MKL S1 4/1/15
REDLINE 15-0062

A1-1
FIRST FLOOR PLAN

GRIME STUDIOS
PORTLAND, MAINE

SHEET TITLE:
FIRST FLOOR PLAN

Drawing file: 1. Original Plans / GRIME STUDIOS - A1-1 FIRST FLOOR PLAN 2014-09-30.pdf

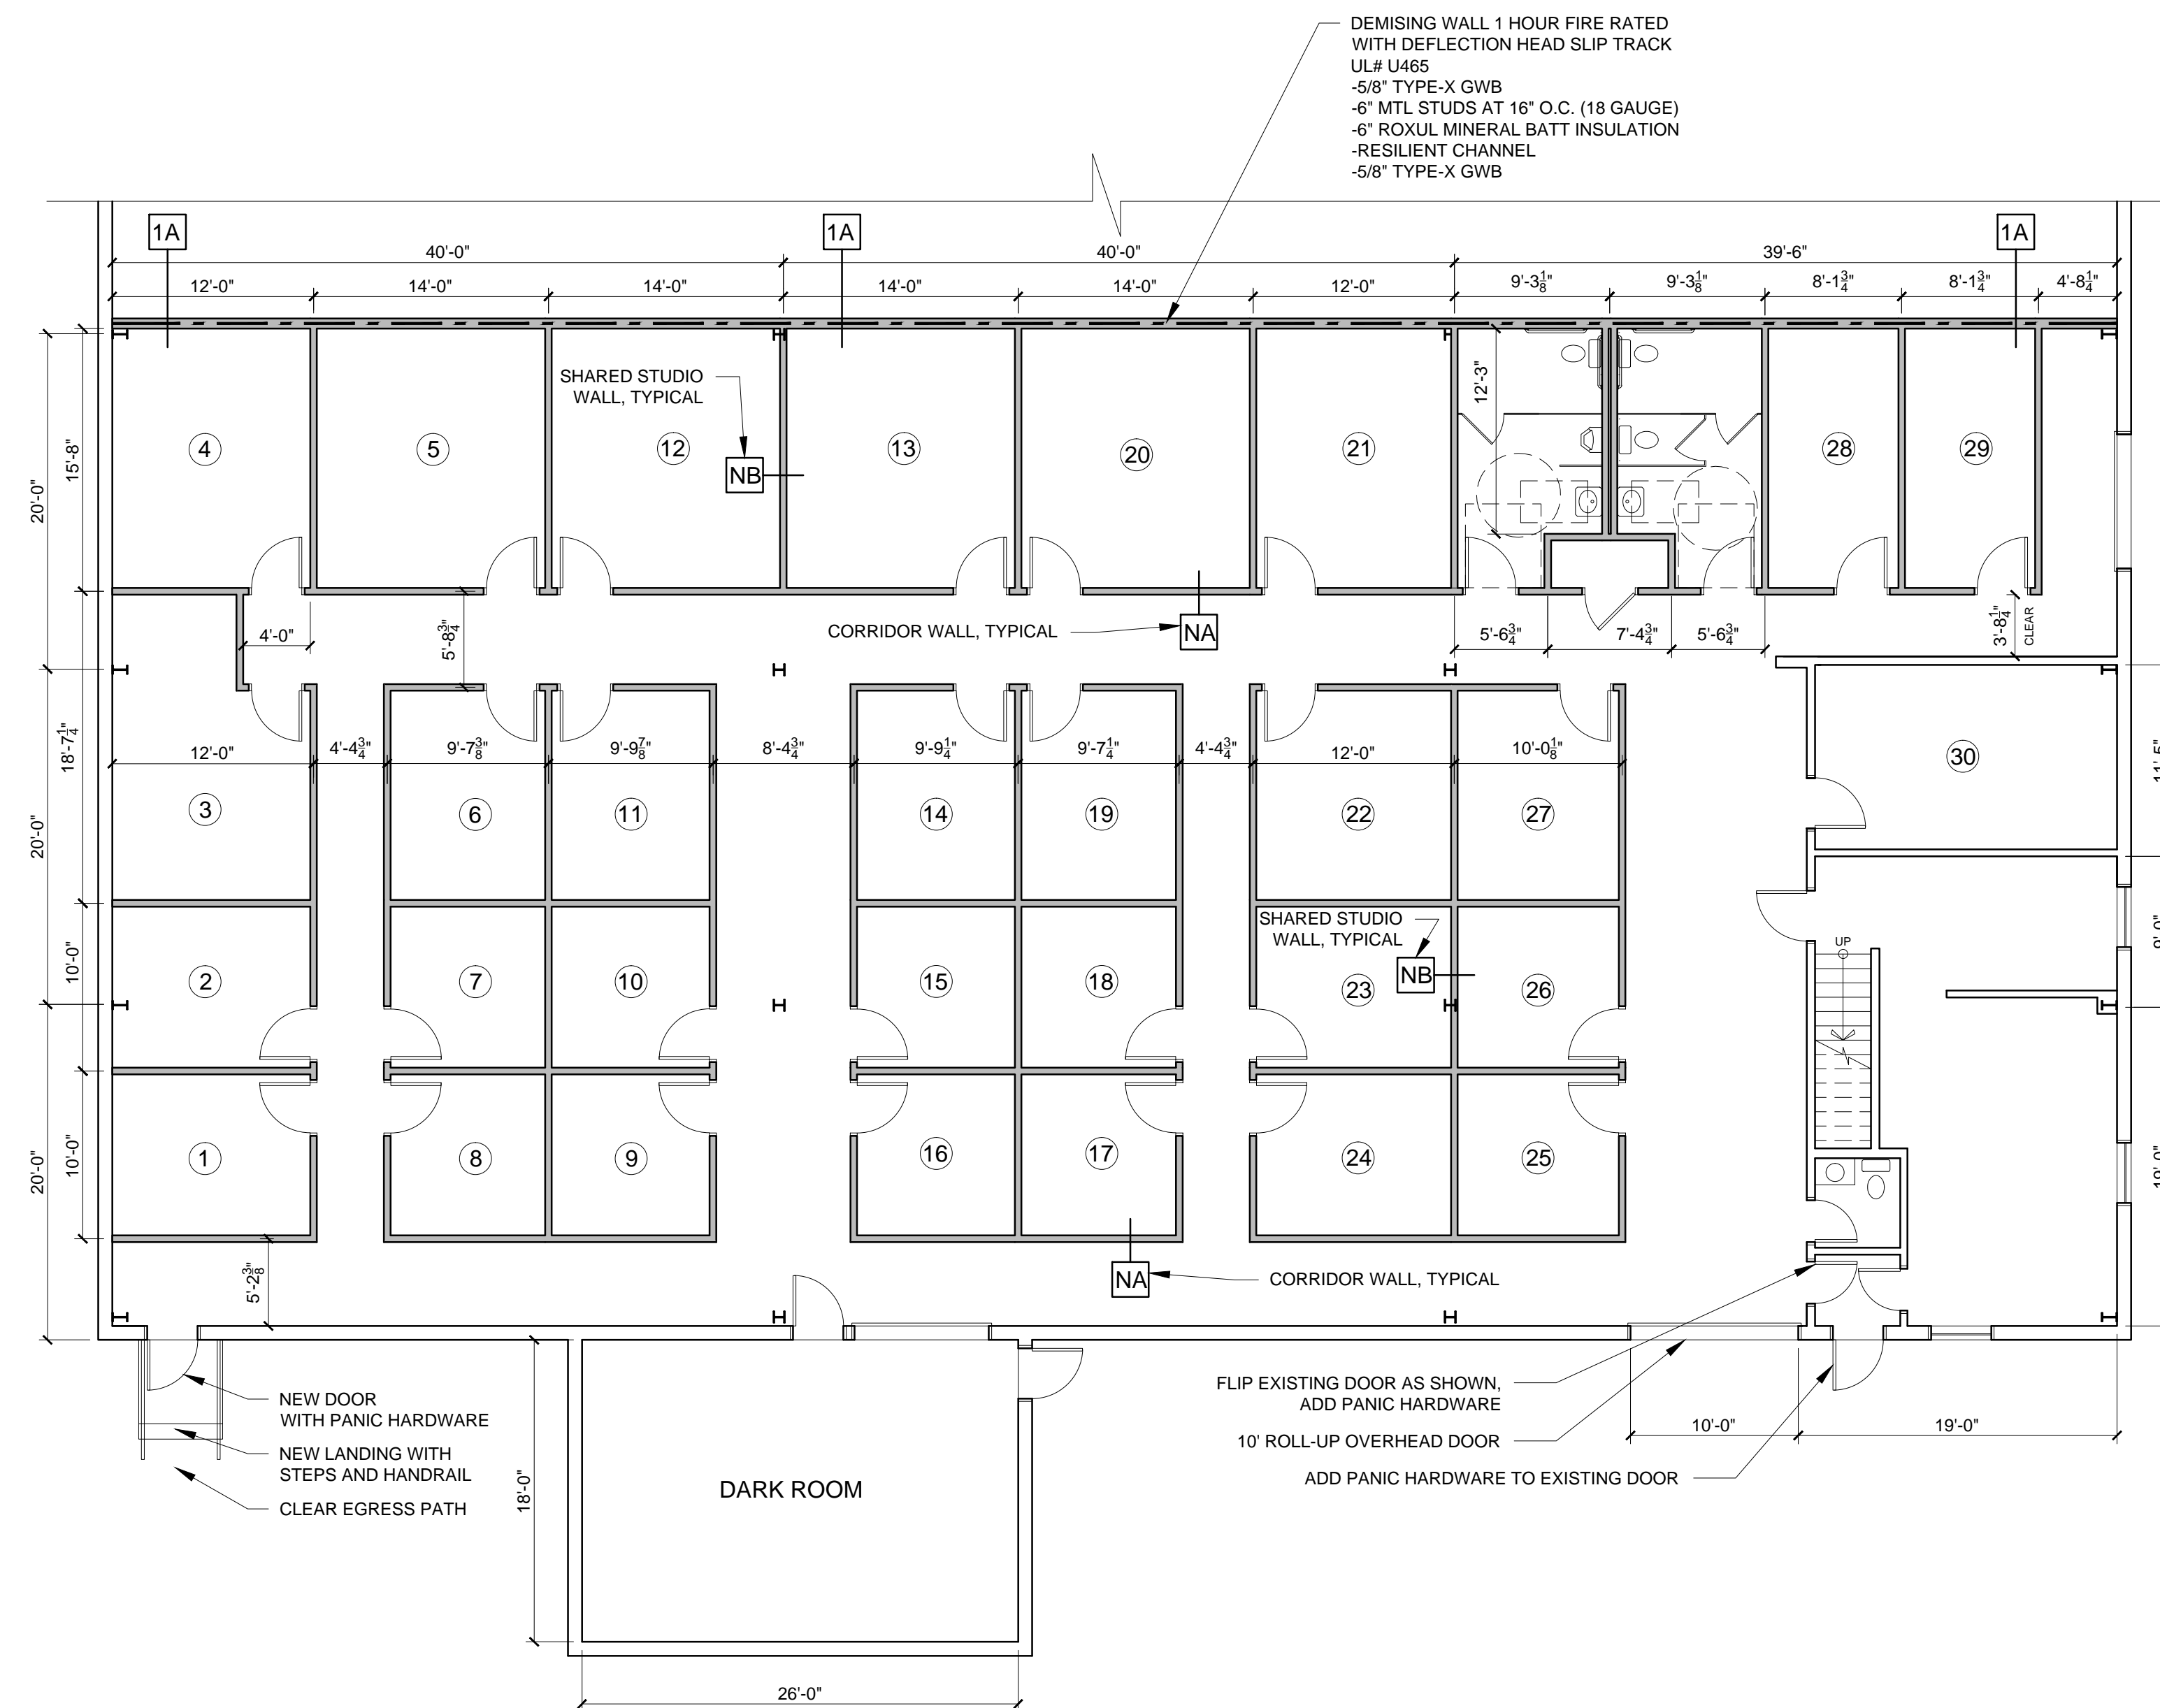
DO NOT BEAR ON THIS WALL - ALL COLUMNS USE ALL PLATE CANT FROM PLATE. PROVIDE DBL FULL HEIGHTS FOR RAY SENIGORE @ (E) PANEL ENDS
